Advice to decision maker on coal mining project

IESC 2015-063: West Muswellbrook Project – New Development

Requesting agency	The New South Wales Mining and Petroleum Gateway Panel
Date of request	27 January 2015
Date request accepted	27 January 2015
Advice stage	Gateway Application

Figure 3-7 Government-mapped highly and less productive aquifers within the PAA and surrounding locality (adapted from McAlister and Dvoracek, 2014)

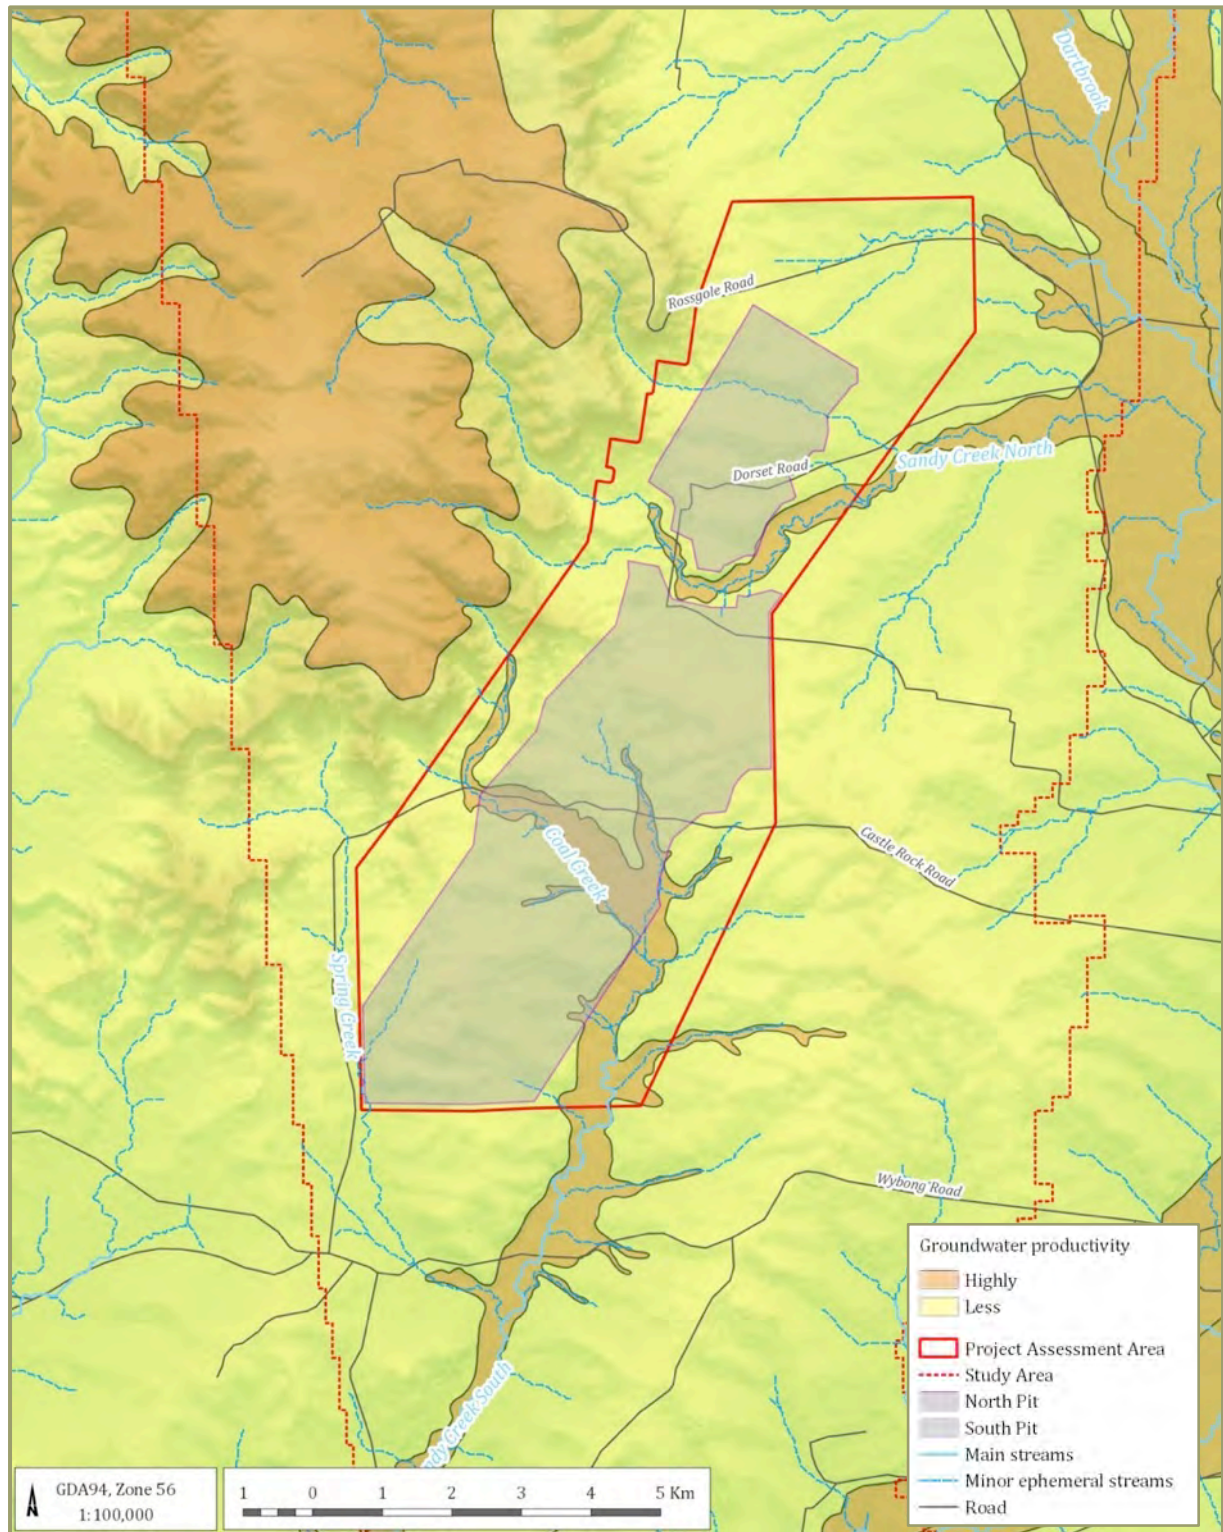
6. The assessment documentation indicates that Coal Creek traverses the proposed location of the southern pit and will be diverted around the mine site. An area of highly productive alluvium associated with Coal Creek will be removed. This is likely to directly affect any groundwater dependent riparian and floodplain vegetation and associated water-dependent ecosystems (instream, hyporheic and groundwater) in the locality. The diversion may also alter flow regimes in the upper reaches of Sandy Creek South, and the water course that receives the diversion.
7. The design and location, and potential impact pathways associated with the Coal Creek diversion are not detailed within the assessment documentation. The diversion has not been incorporated in preliminary modelling studies.

- c. Description and comparison of the various design options for the diversion of Coal Creek which includes comparison of the potential impacts of each option (e.g. increased sediment loads, and impacts to hydrology and geomorphology of receiving surface water courses).

Figure 4-2 Bores within the Project Assessment Area and immediate surround with a predicted >2 m drawdown (adapted from McAlister and Dvoracek, 2014)

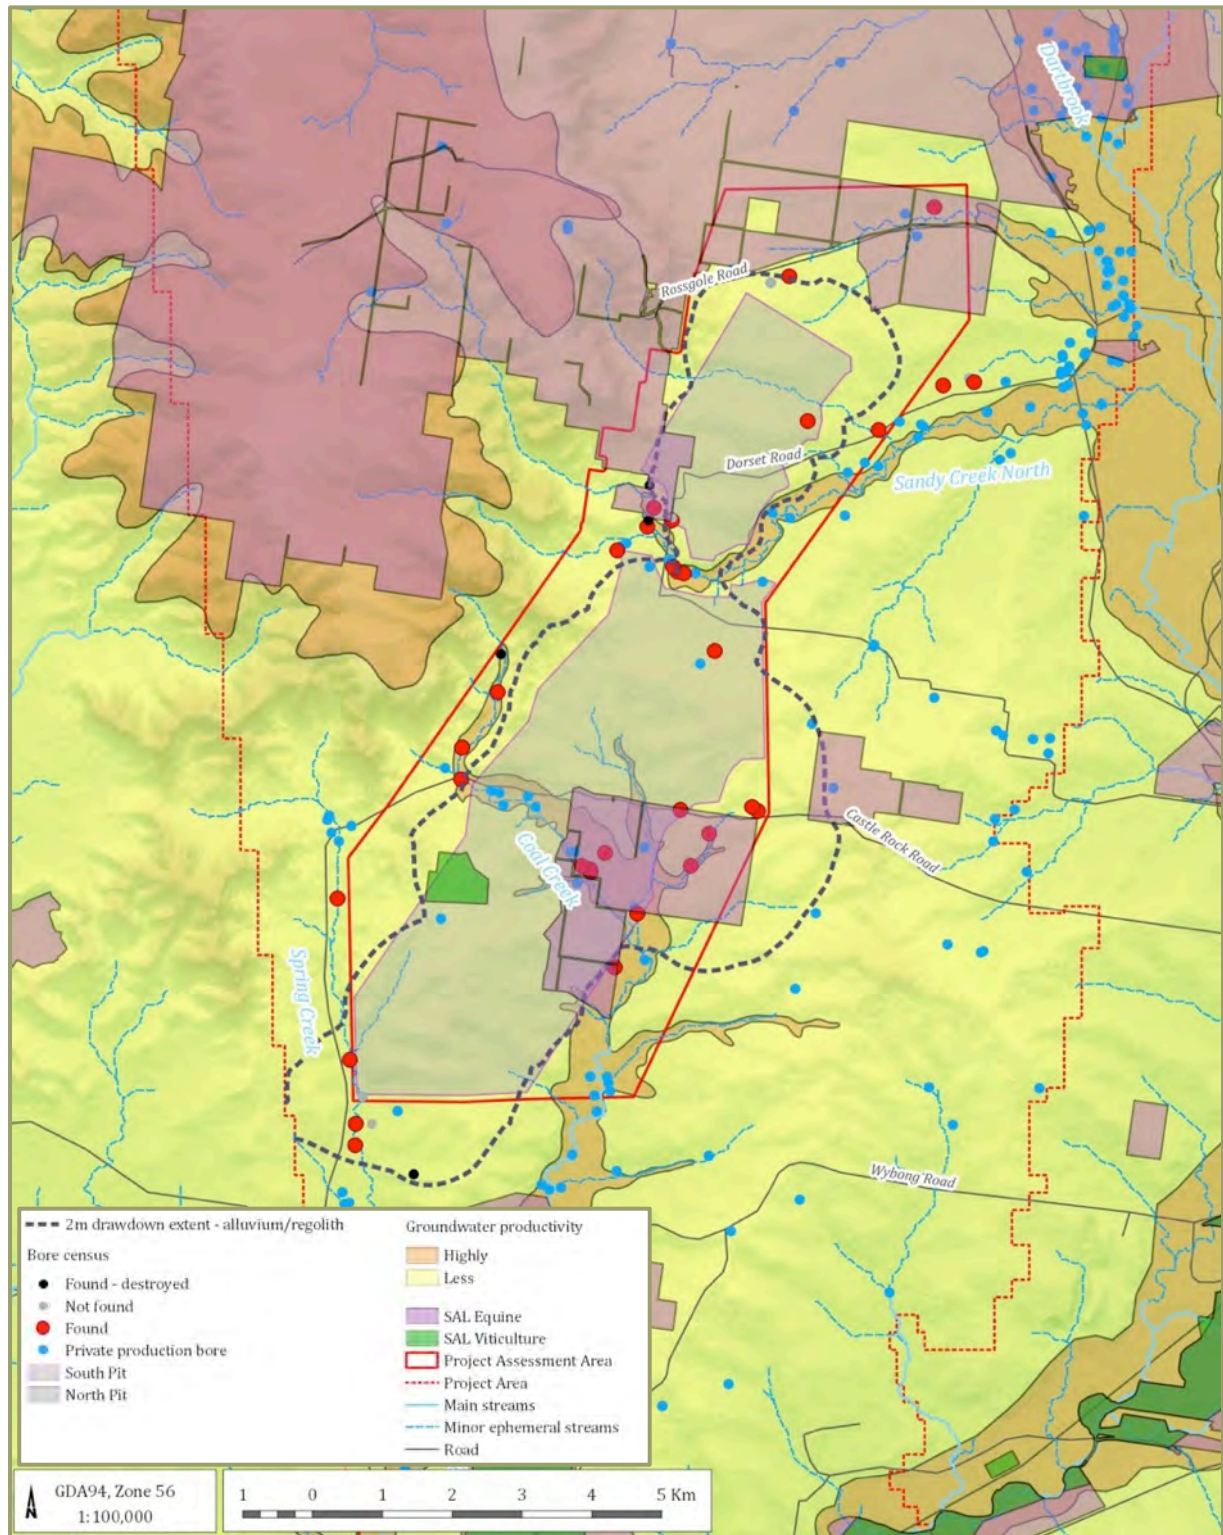
3. Groundwater drawdown in the target coal seams and overlying hydrological units has the potential to impact water levels in private bores, baseflow to local creeks, groundwater dependent riparian and floodplain vegetation, and associated water-dependent ecosystems.
4. Extraction of groundwater due to mining is expected to reduce groundwater inflows to alluvium. Numerical modelling over the life of the mine has predicted groundwater level reductions in the alluvium associated with Sandy Creek North, Sandy Creek South, Spring Creek, and Coal Creek.
5. Preliminary modelling indicates 37 private bores are predicted to be impacted by a drawdown of greater than 1 metre. Of these bores, 16 are located within the mining footprint and will be removed and eight lie outside of the Project area.

12. Mitigation measures to address potential impacts to water resources have not been considered, with the exception of:
- a. a 150 metre buffer between proposed mining and the edge of alluvium associated with Sandy Creek South, Sandy Creek North and Spring Creek. It is unclear why this distance was selected
 - b. a commitment to enter into 'make good' arrangements for landholder bores affected by a greater than two metre drawdown.
